KITTITAS COUNTY

MEMORANDUM

TO: All Staff
FROM: Public Works Plan Review Team
DATE: November 28, 2022
SUBJECT: LP-22-00005 Suncadia Phase 2 Division 8 Revised for 111722 Submittal

SUNCADIA RESORT LLC  
**PHASE 2 DIVISION 8**  
 CONCEPTUAL UTILITY PLAN  
 KITTITAS COUNTY WASHINGTON

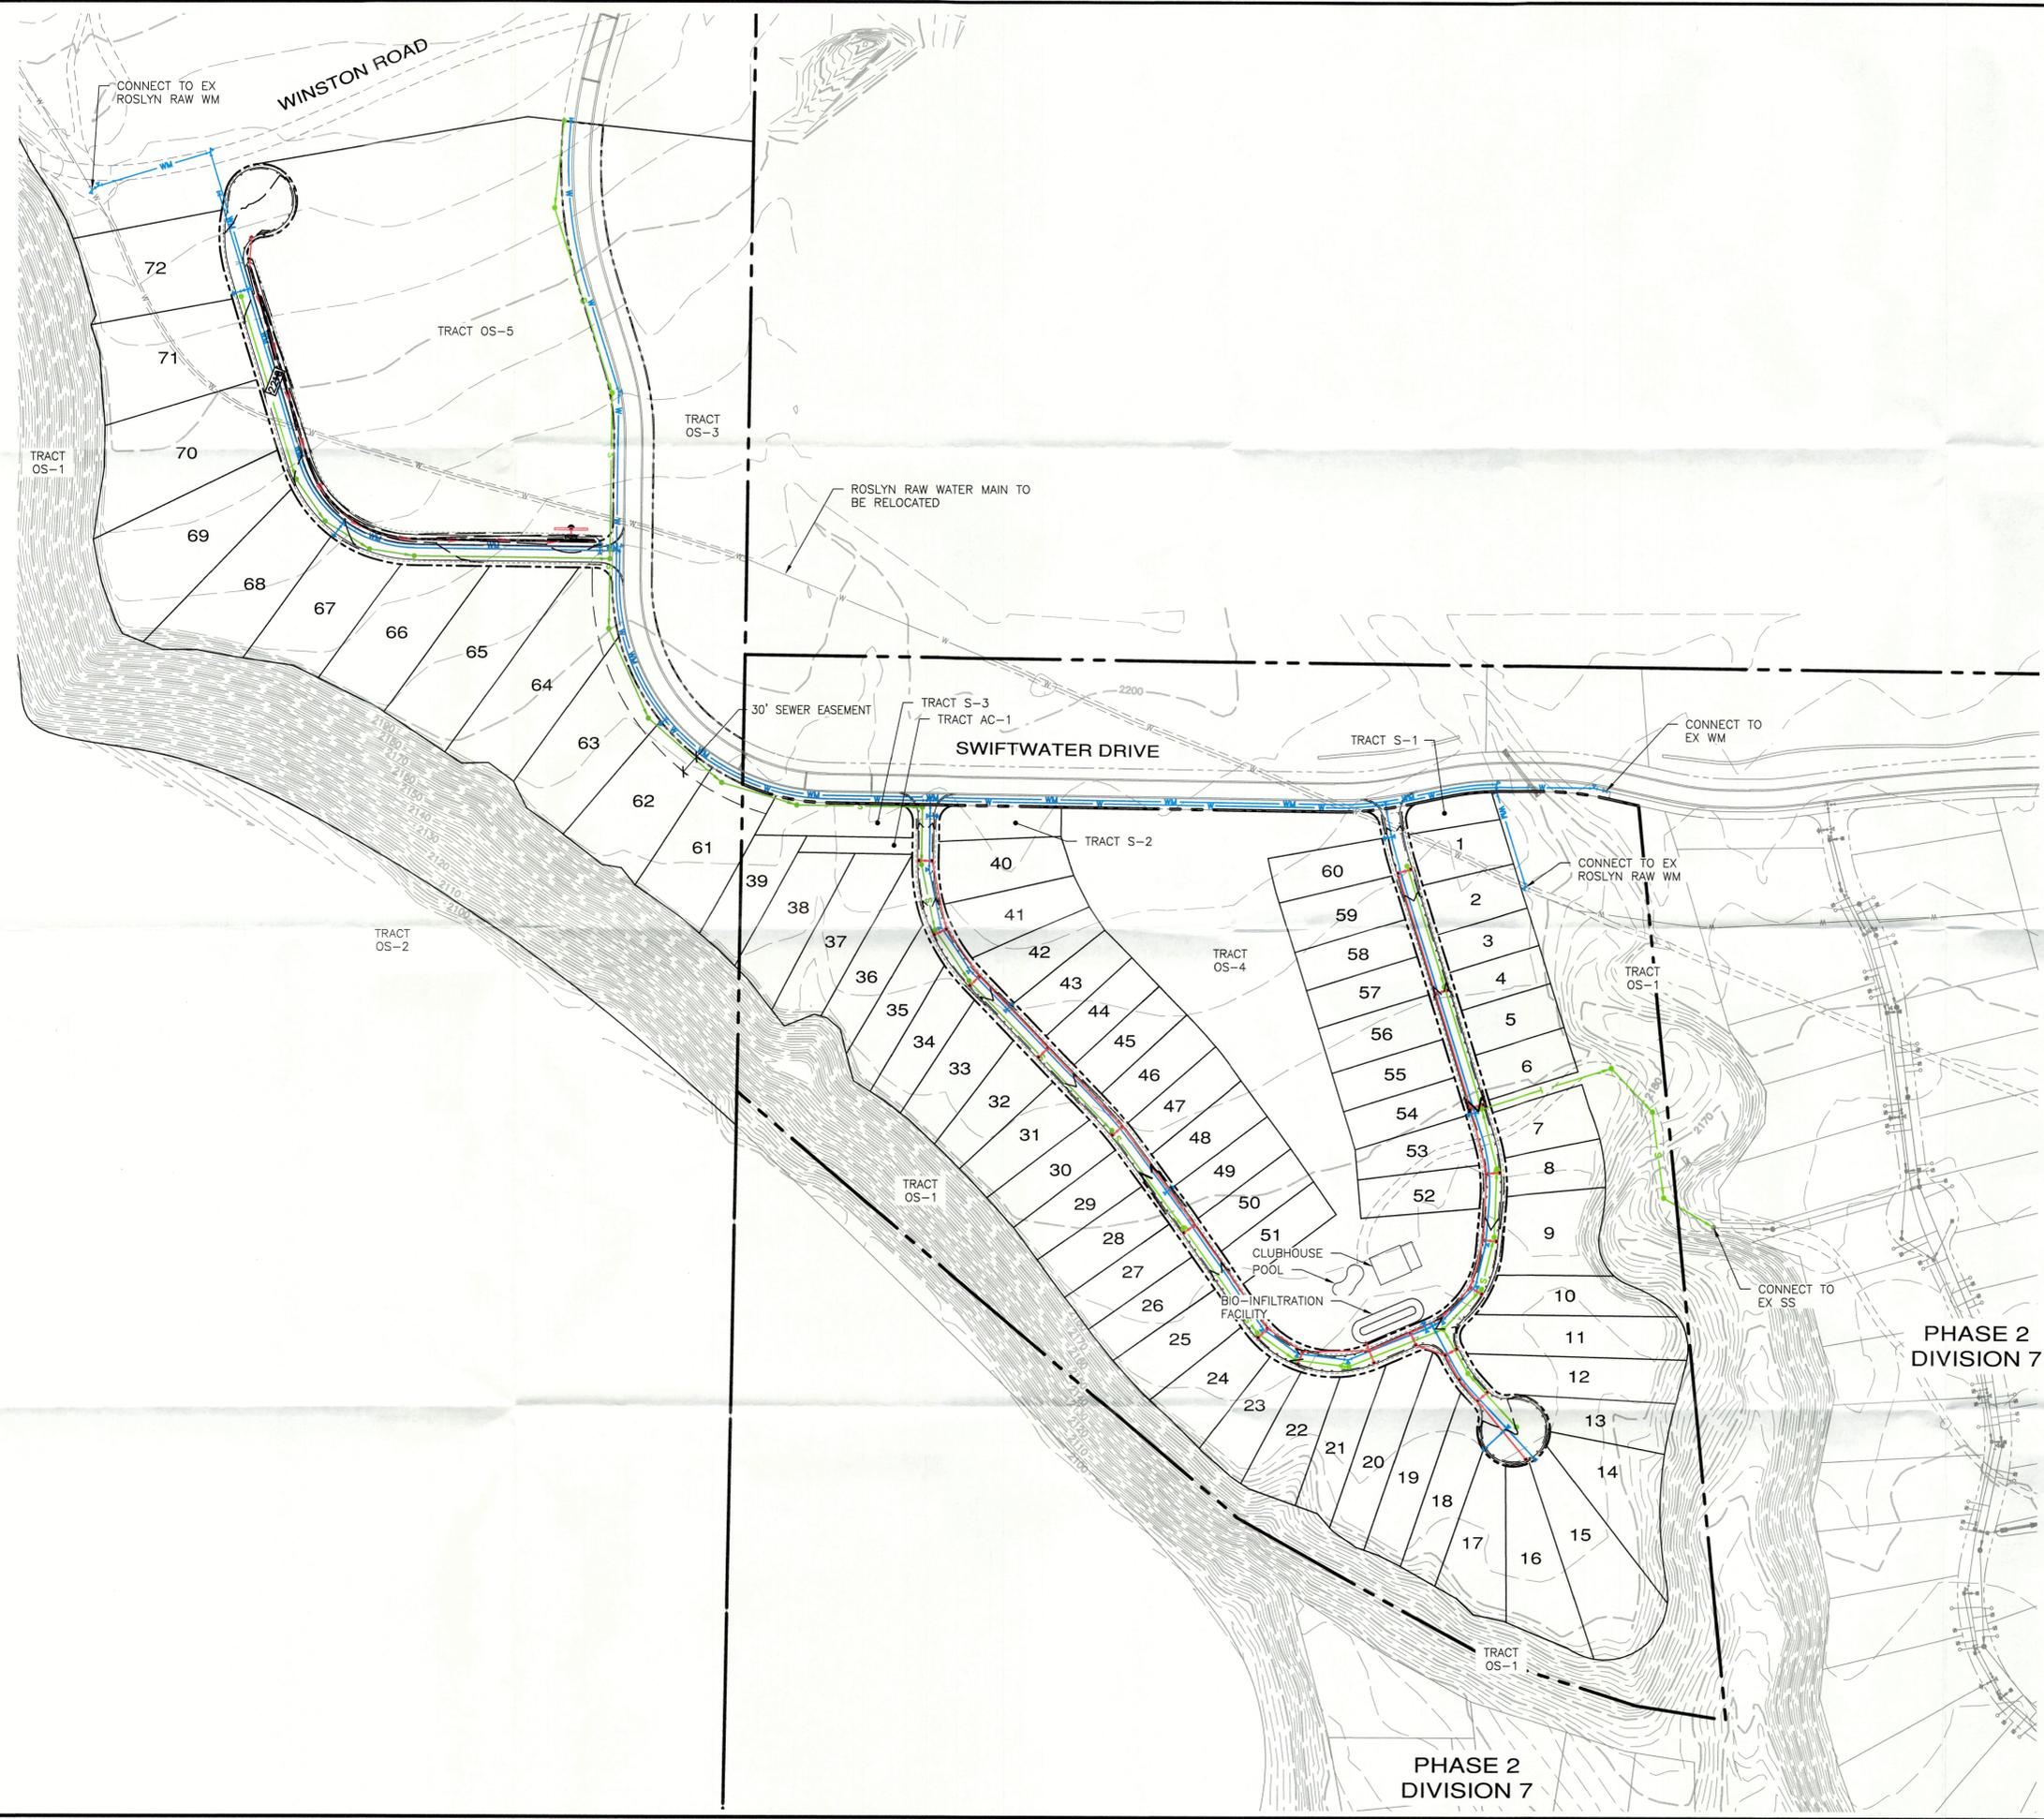
<ul style="list-style-type: none"> • Please provide an inventory of equivalent residential units, or the accounting method utilized in the water system plan, affirming sufficient capacity serving the plat. • Please provide an inventory of equivalent residential units, or the accounting method utilized in the general sewer plan, affirming sufficient capacity serving the plat. • A transportation impact analysis (TIA) shall be required for all development that will generate more than nine (9) peak hour vehicle trips. Please provide estimated traffic generation for peak hours to determine if a TIA will be required. (KCC 12.10.040(c))
ENGINEERING	<ul style="list-style-type: none"> • A civil review will be required through Public Works.
SURVEY	<ol style="list-style-type: none"> 1. Name of Subdivision at top center of page. (All Sheets) 2. include Engineer of Record. (Sheet 1) 3. Include area labels or tables for all Open Space, Service and Future Development Tracts. (All Sheets) 4. For existing roads, include ownership, width, and surfacing. (EX: Swiftwater Drive – 60’ wide private R/W – Paved) 5. For all ROW’s identify if there are Existing or Herein Dedicated. (All Sheets) 6. Identify Swiftwater Drive, Winston Road, and Bakers Road as topo features in Section 11. No dimensioning or ROW creation needed. (Sheet 6) 7. Show and Label Cle Elum River. (Sheet 6) <p>SURVEY UPDATE 11/28/2022 All prior survey comments have been addressed as part of the updated plan set.</p>
